Subject: RE: AL/106/19/DOC

Further to my previous response to this application for Condition 7 (CMP), I asked for further detail on their complaint procedure in the CMP should there be a lighting complaint. They have just stated 'in the event of any queries or concerns the site manager is contactable'. Given that we have already had a lighting complaint about this site, I would appreciate it if they could expand more to advise of their complaint procedure in the event of a lighting complaint. I am satisfied with the noise part of the CMP, now they have put more detail into it.

REV. No.	DATE	DESCRIPTION	INITIALS
Client			
Project	Westergate & Eastergate		
Title	External Works Layout Sheet 1	Scale 1:250@A0 Checked AMc	Date Mar '18 Drawn KT
Drawing No.	5655:40	Rev	H

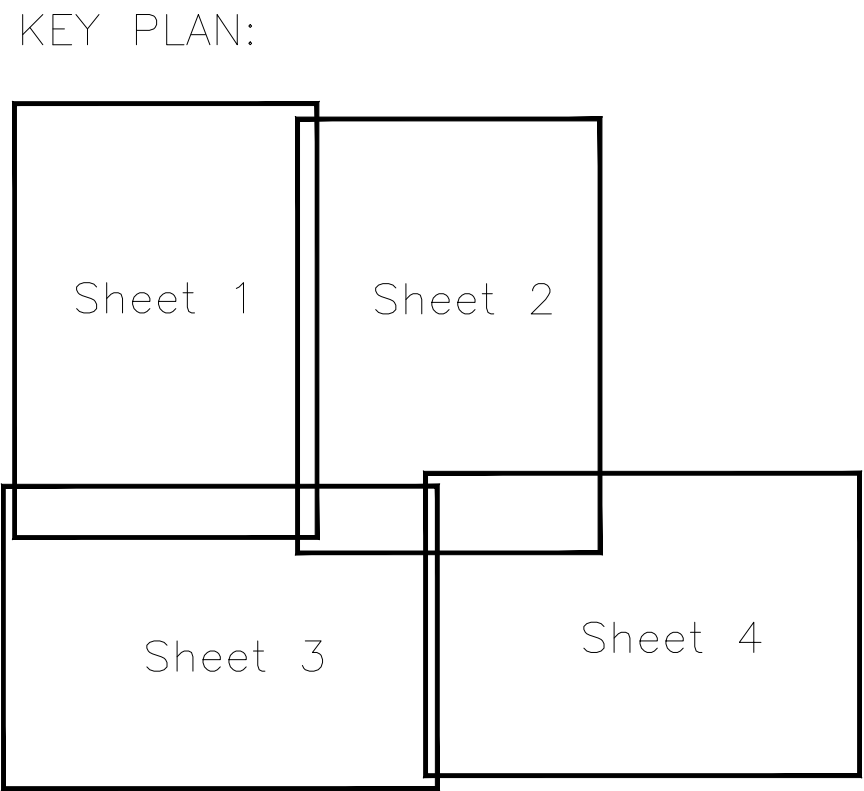
I haven't been able to find confirmation of the fact that the Lighting Schedule complies with Zone E2 of the ILP guidance – as discussed there are a couple of documents that the Planning Portal seems intent to keep me away from! If you could point me to the documentation that contains the Zone E2 confirmation I would be very grateful.

DRG. No.:		20627/001/CMP	REV.: C

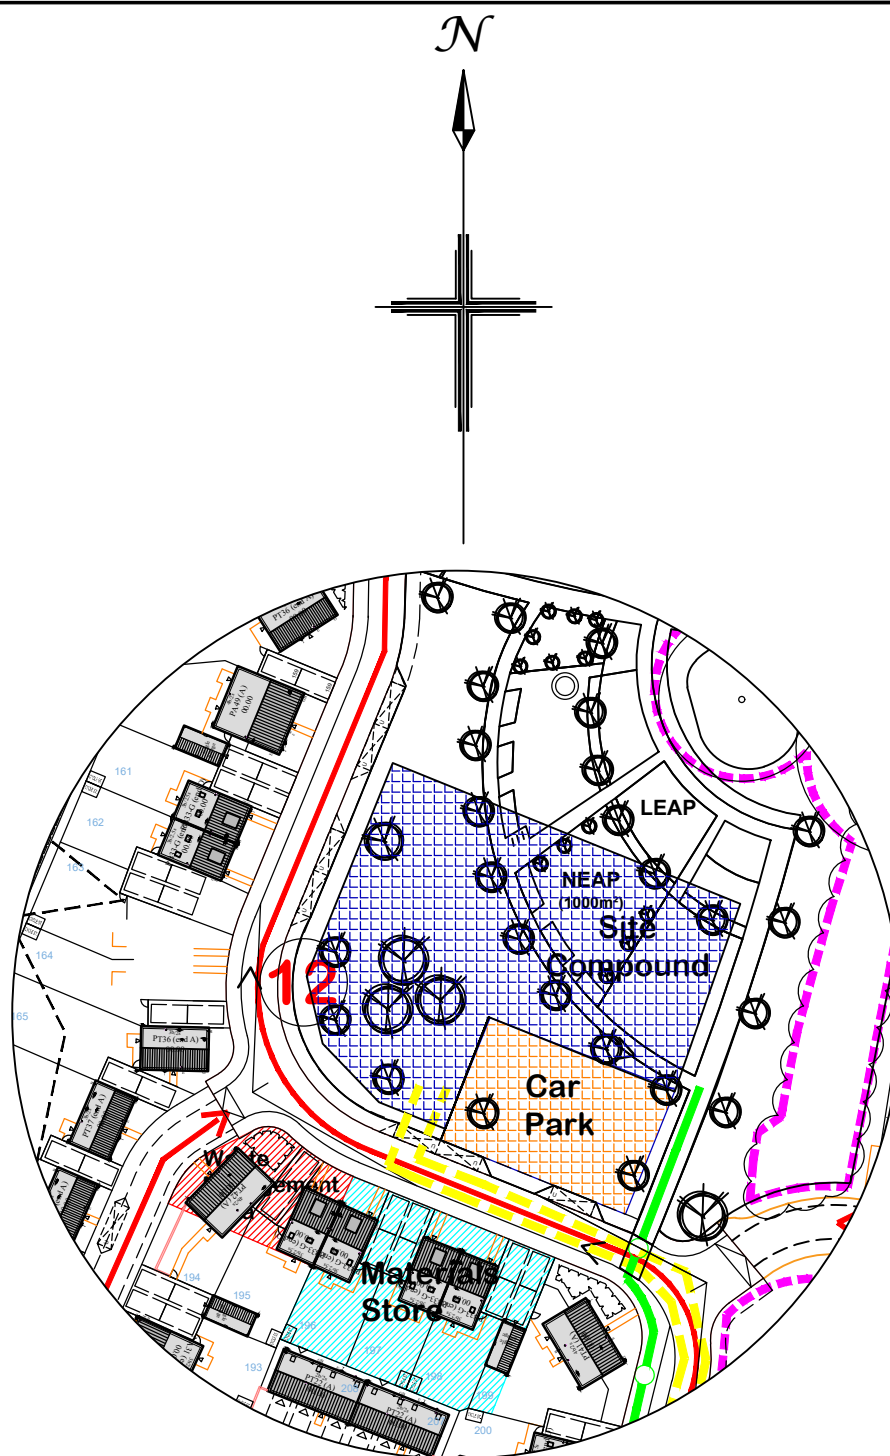
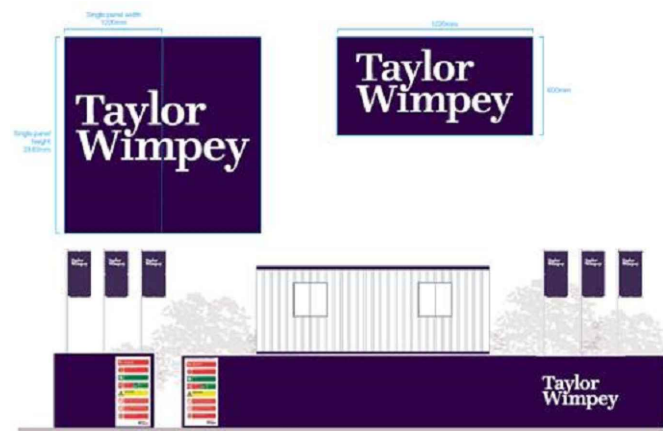
Thanks, Environmental Health are satisfied that Condition 10 can be discharged. Just waiting for the expansion of the information if a lighting complaint is received.

Thanks for the updated information on lighting in the CMP. Environmental Health is now satisfied that the CMP (condition 7) can be discharged.
